Project Title: Land South of Ford Lane

Title: Stage 1 Road Safety Audit – GG119 Response Format

Ref: DS/ITB14679-006B

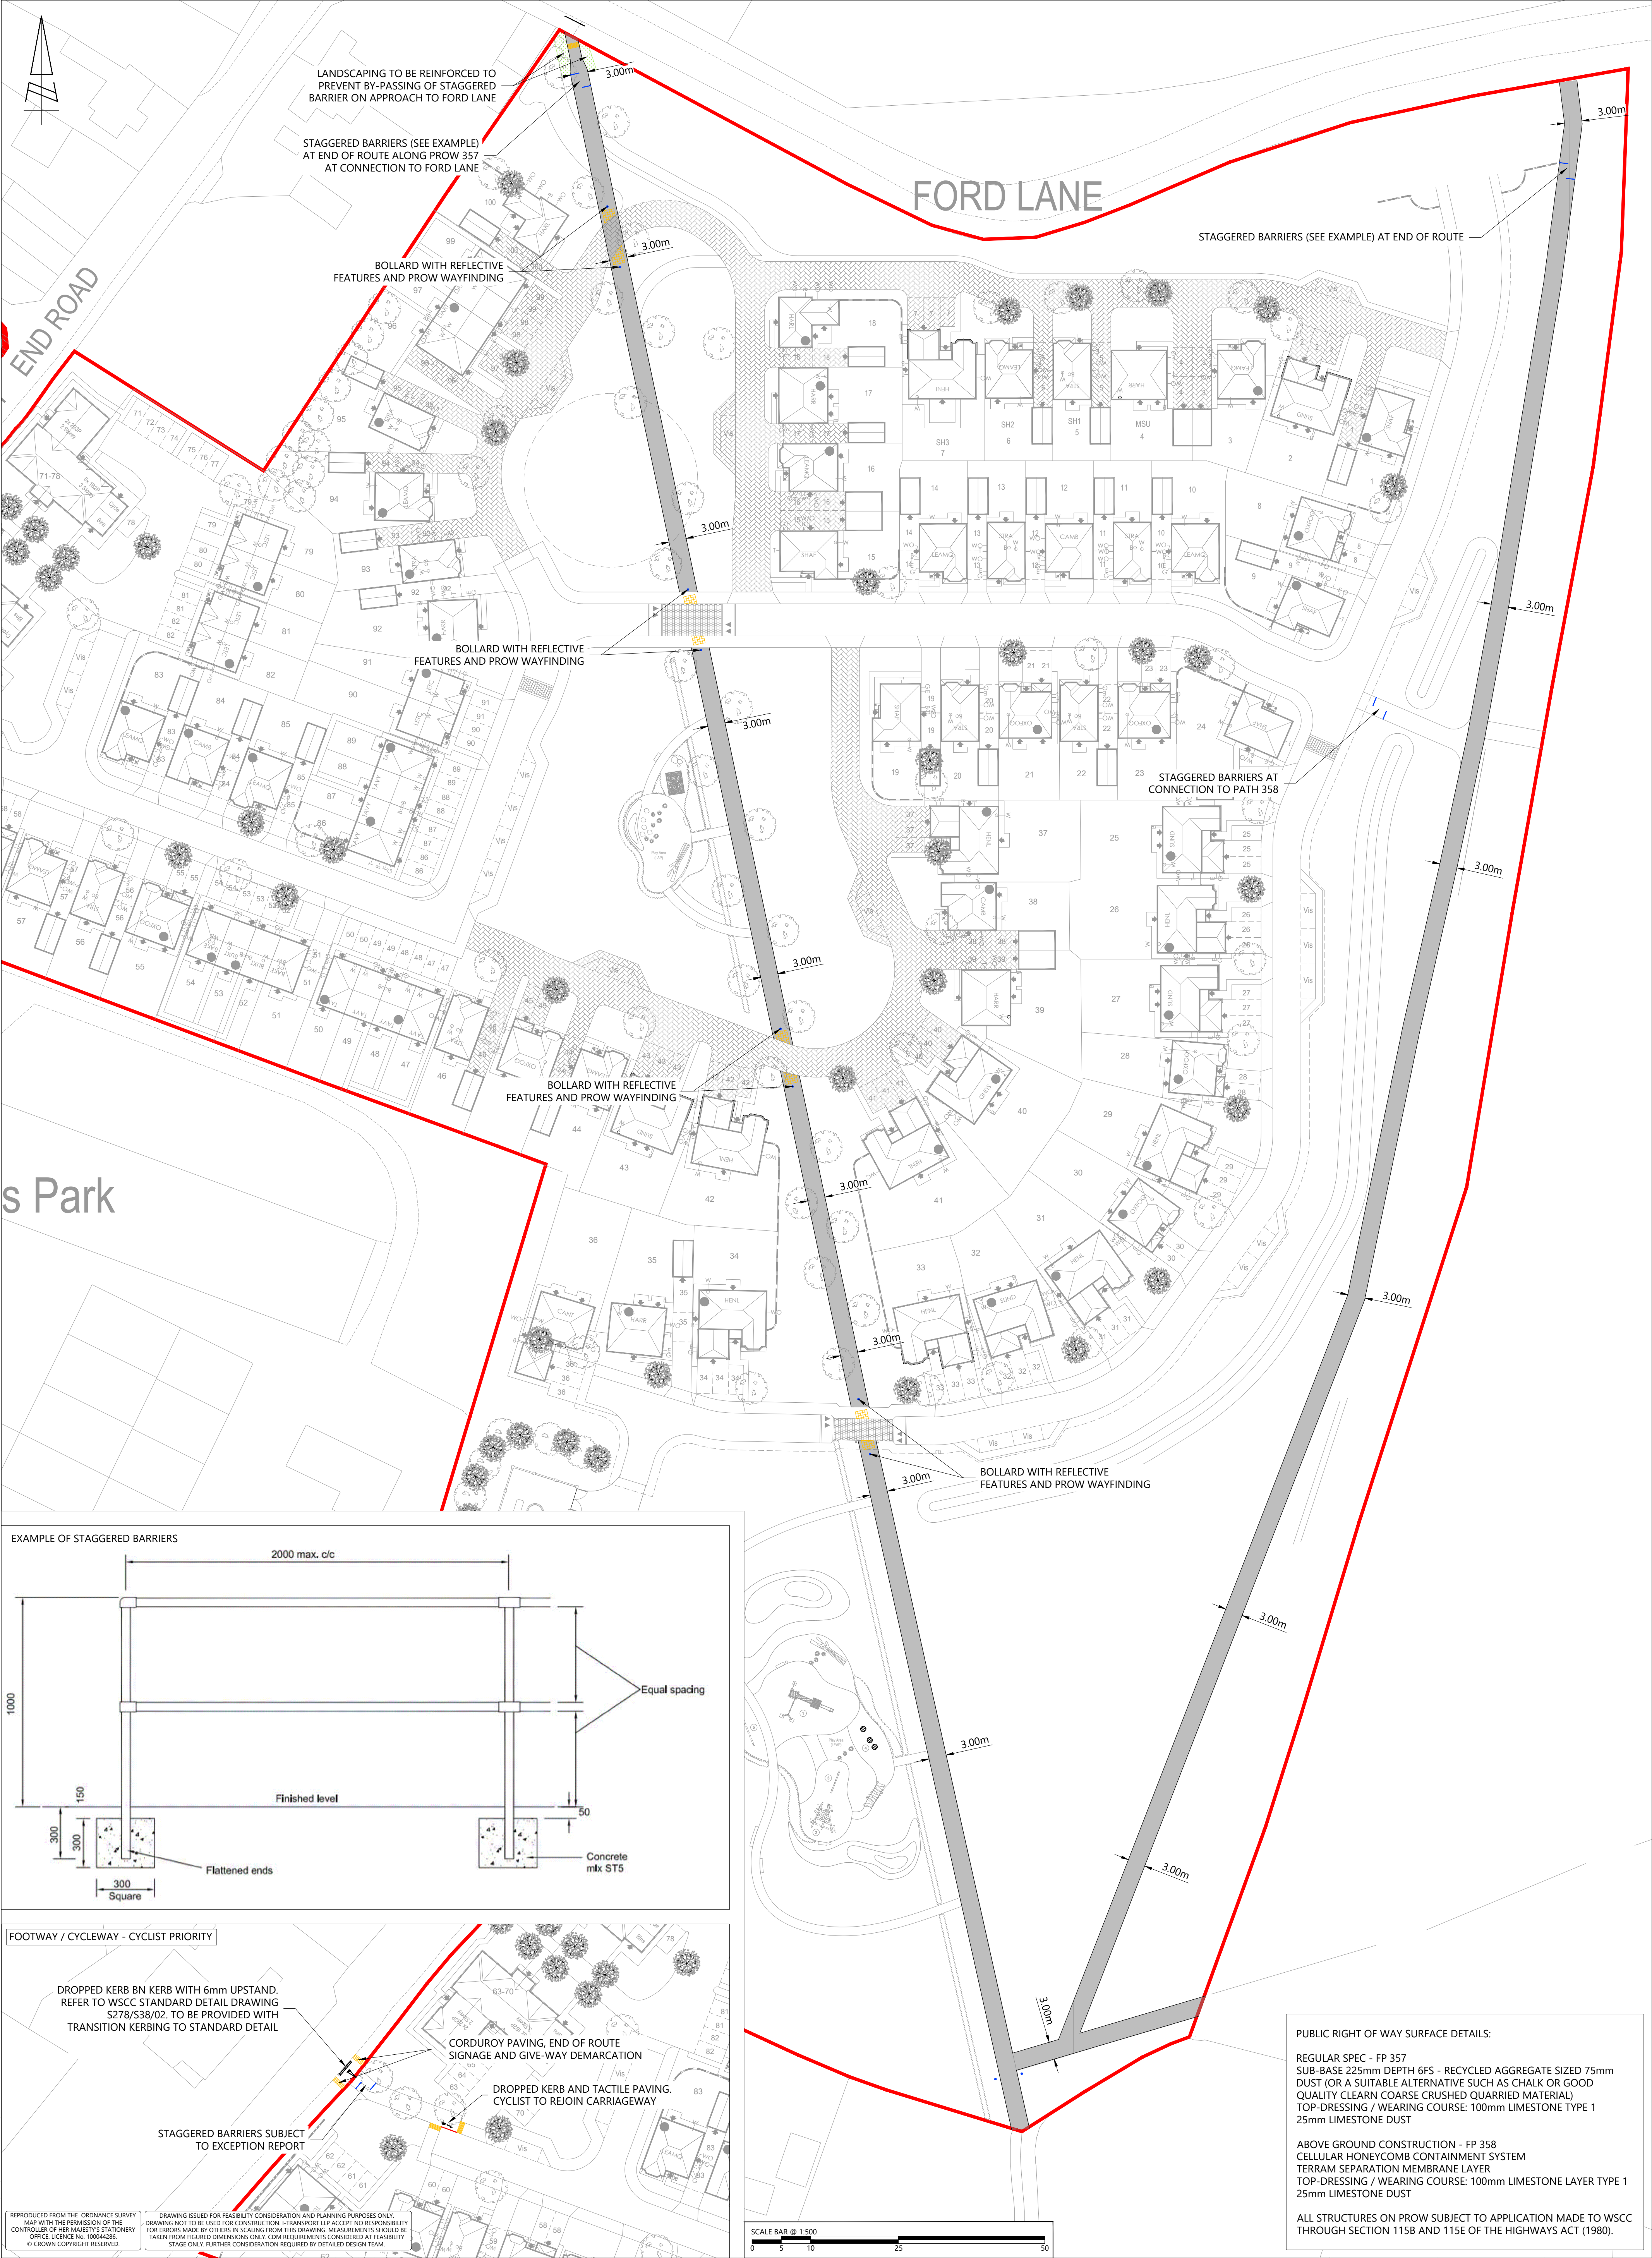
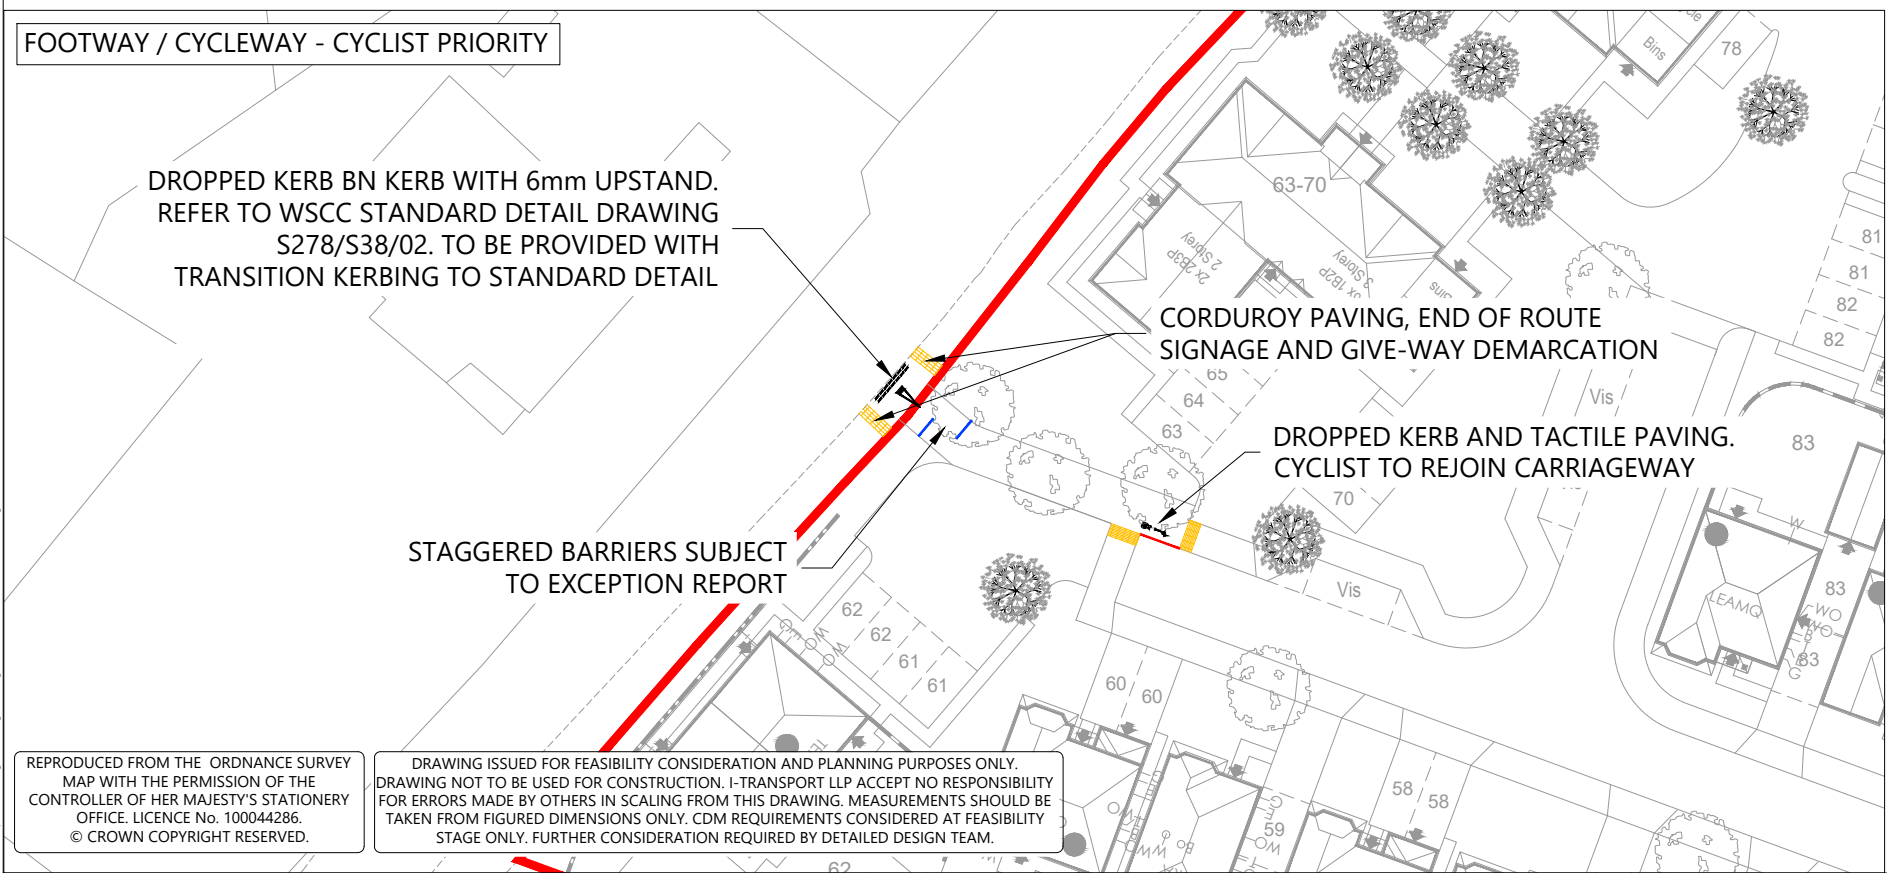
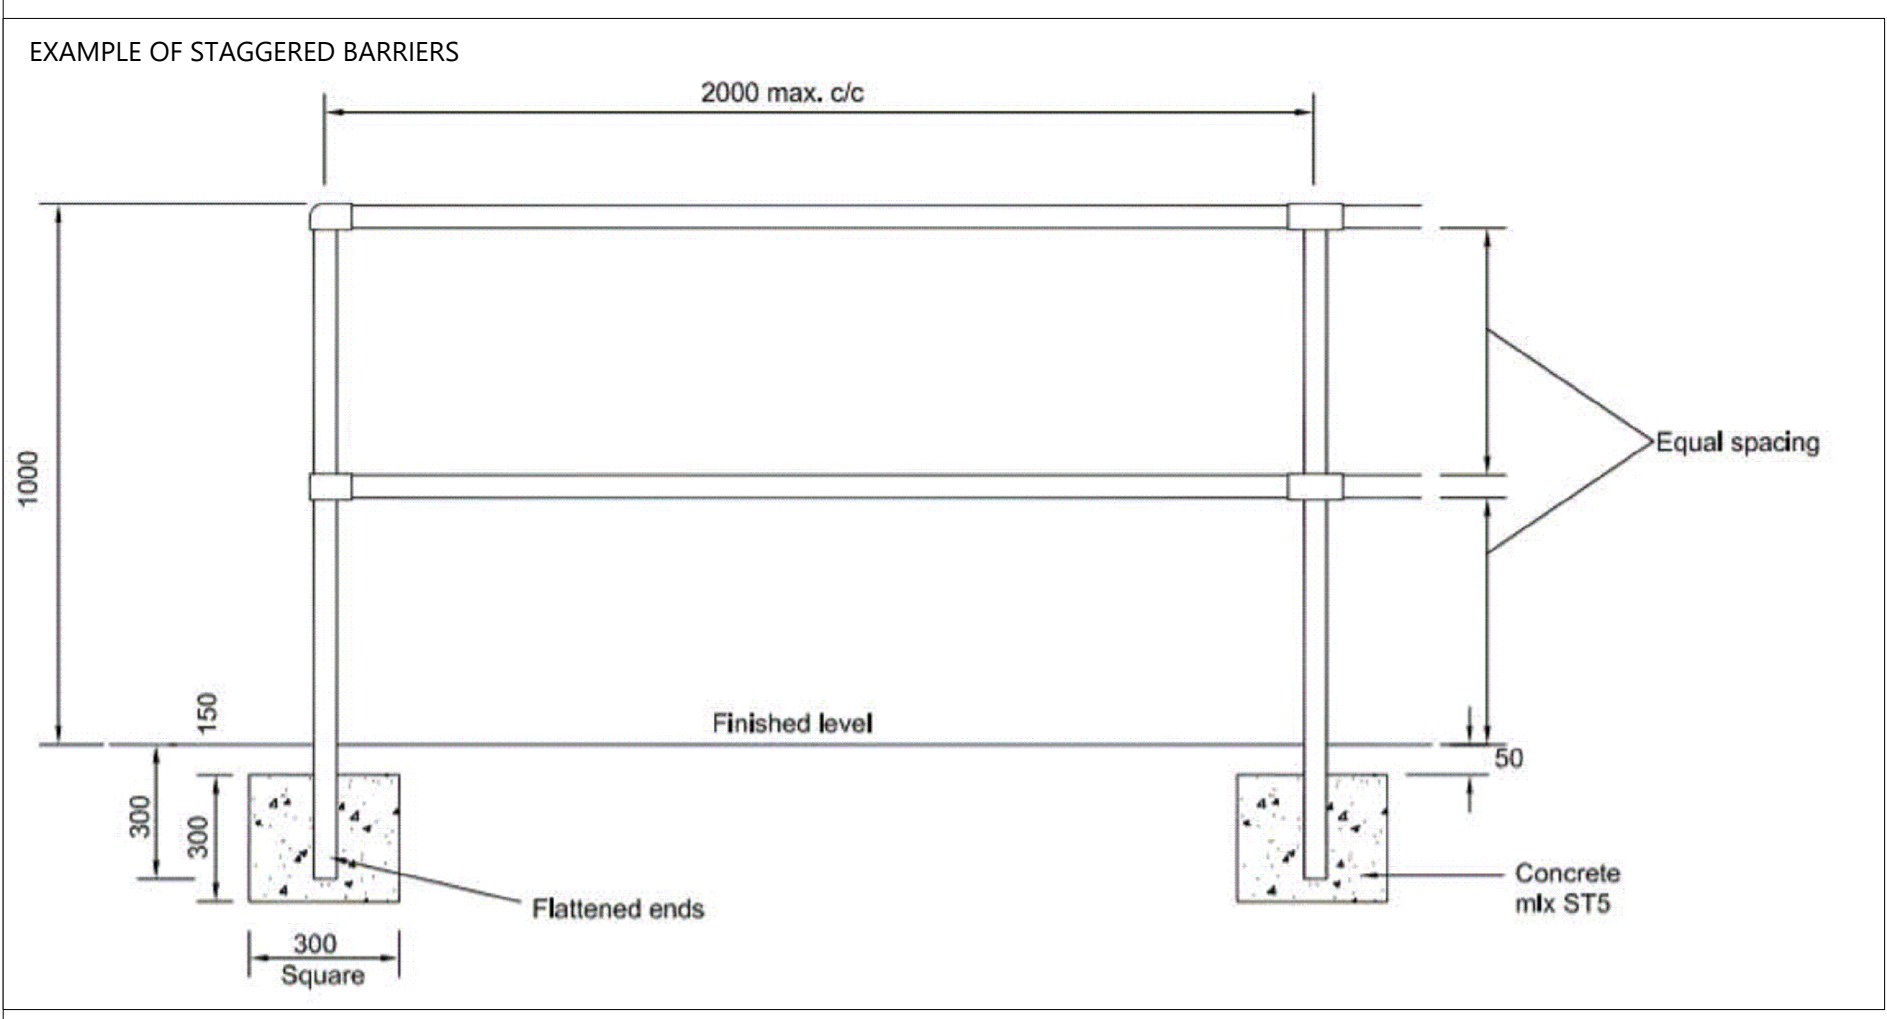
RSA Problem	RSA Recommendation	Design Organisation Response	Overseeing Organisation Response	Agreed RSA Action
2.1: Footpath 357 forms a public right of way that currently passes between the southeast and northwest extents of a field meeting footpaths 358 and 359 to southeast and Ford Lane to the northwest. The field is set above the level of the Ford Lane carriageway with access gained via a set of 6 uneven concrete slab steps with a wooden handrail, up the grass embankment. The Audit Brief that has been supplied to provide sufficient information to undertake this Stage 1/2 Road Safety Audit, states that the connections between the site and existing rights of way which are outside the redline boundary, are outside the scope of the Audit and that the current proposals are to provide footpaths within the application site. However, it is understood that there are aspirations to upgrade footpath 357 to a footway cycleway. Whilst the existing connection between the footpath and Ford Lane allows pedestrian to walk up steps that are currently substandard and result in a pedestrian stepping straight onto the carriageway, the use of the connection by cyclists would result in the requirement for a bicycle to be transported up / down steps and could lead to cyclist falling and a personal injury or falling into the Ford Lane carriageway into the path of a vehicle resulting in a vehicle cyclist collision.	It is recommended that the northern most section of footpath 357 is reduced to 2 metres and measures are provided to deter use by cyclists with landscaping / planting provided either side of the staggered barriers to ensure that cyclists cannot bypass the measures.	Accepted – the width of the footway has been narrowed to 2m and landscaping features have been identified on either side of the path/barrier to prevent by-passing of the infrastructure. The revised design is presented in drawing ITB14679-GA-002 Rev C.

RSA Problem	RSA Recommendation	Design Organisation Response	Overseeing Organisation Response	Agreed RSA Action
2.2 The existing footpath 357 that passes through a field to the east of North End Road and south of Ford Lane in an unmade and narrow route that is uneven in places. The proposals subject to this Stage 1/2 Road Safety Audit include the widening of the existing footpaths to 3 metres and the reconstruction with a 225mm base course below 75mm of dust and 100mm of limestone type 1 topped with 25mm of limestone dust which will provide an adequate surface that is cambered to ensure surface water drains to the soft verges either side that are detailed on the landscaping plans associated with the approved application Y/112/20/DOC. The current proposals illustrated on dwg ITB16479-GA-002 revision B included with the Audit Brief, identifies that staggered barriers are to be provided adjacent to all locations where the public right of way crosses the on-site roads. The scheme drawing also identifies that raised tables or shared surface areas are to be provided where the footpath crosses the on-site roads and the landscaping plans indicate that the crossings are to be fairly open with no high-level planting provided in close proximity. Whilst staggered barriers assist in slowing users to ensure that they proceed with caution, users tend to bypass the measures if a route is available. It is therefore likely that users of the public right of way, will bypass the staggered barriers on the adjacent soft verge which is likely to become uneven as a result of use particularly during inclement conditions. An uneven surface could give rise to trips, falls and personal injury.	It is recommended that the staggered barriers are replaced with bollards that include reflective features to reduce the likelihood of users bypassing the surfaced route and crossing at a location away from the dropped kerb crossing points that benefit from tactile paving.	Accepted – the staggered barriers have been removed from the internal aspect of the layout and replaced with bollards. The bollards with the fitted with reflective material, and also incorporate way-finding for the Public Right of Way. The amendments are presented in drawing ITB14679-GA-002 Rev C.

RSA Problem	RSA Recommendation	Design Organisation Response	Overseeing Organisation Response	Agreed RSA Action
4.1: The proposals that are subject of this Stage 1/2 Road Safety Audit include the provision of a surfaced 3 metre route for pedestrians through a proposed development between footpath 358 and Church Lane to the south and Ford Lane to the north as illustrated on dwg ITB16479-GA-002 revision B included with the Audit Brief. The proposed route is to cross the on-site roads that are to facilitate vehicular access, a number of times with two crossing of shared surface areas and two crossing of general carriageway where the crossing point is to be provided on a raised table. Each of the crossing locations is in-line where pedestrians walk towards the carriageway and are to consist of dropped kerbs that are understood to include an upstand of between 0 and 6mm and benefit from tactile paving. However, as illustrated on the scheme drawings, a minimum of two rows of tactile paving slabs are to be provided allowing for a minimum depth of 0.8 metres. Pedestrians could step across two rows of tactile paving and as such, visually pedestrians could enter the carriageway without warning. The crossing points are to be provided at shared surface areas or where raised tables are provided and as such, vehicles should be proceeding with caution at a low speed, however, a pedestrian entering the carriageway and the path of a vehicle without warning, could lead to vehicle pedestrian collisions. Furthermore, no tactile warning surface is provided adjacent to the stepped access to Ford Lane which could lead to pedestrians falling down the steps into the carriageway	It is recommended that tactile paving is provided for a minimum depth of 1.2 metres where pedestrians walk towards a hazard i.e. carriageway of steps.	Accepted – tactile paving depth has been increased to a minimum of 1.2m through the scheme, and additional tactile paving has been incorporated on FP357 on the approach to Ford Lane. The amendments are presented in drawing ITB14679-GA-002 Rev C.

RSA Problem	RSA Recommendation	Design Organisation Response	Overseeing Organisation Response	Agreed RSA Action
4.2: The proposals that are subject of this Stage 1/2 Road Safety Audit include the provision of a surfaced 3 metre route for pedestrians through a proposed residential development that is lightly trafficked and accommodates a network of footways alongside the on-site roads. The scheme drawing provided with the Audit Brief, identifies that whilst pedestrian access to the site can be gained via connections to Public Right of Way 358 to the northeast, 358, 359 and to the south, and 357 to the northwest, a new link is to be provided to the via a shared footway cycleway facility to North End Road to the west. Hazard warning tactile paving is to be provided where the proposed on-site footways meet the shared facility allowing pedestrians travelling from the development to become aware of the change in use and potential for cyclists, however, no tactile warning surface is provided where the shared facility crosses the existing North End Road footway. Furthermore, no facilities are provided to allow cyclists level access between the shared footway cycleway and North End Road carriageway. The lack of tactile warning surface along the existing footway could give rise to pedestrians, particularly the visually impaired, walking into the path of cyclists without warning and the lack of measures to allow level access between the carriageway and shared facility, could lead to cyclist falls.	It is recommended that a hazard warning tactile surface is provided in accordance with national guidelines	Accepted – Section 278 Agreement has been entered into for works to be undertaken on the highway outside of the redline boundary. However, corduroy paving and end of route signage has been incorporated into the revised design ITB14679-GA-002 Rev C.
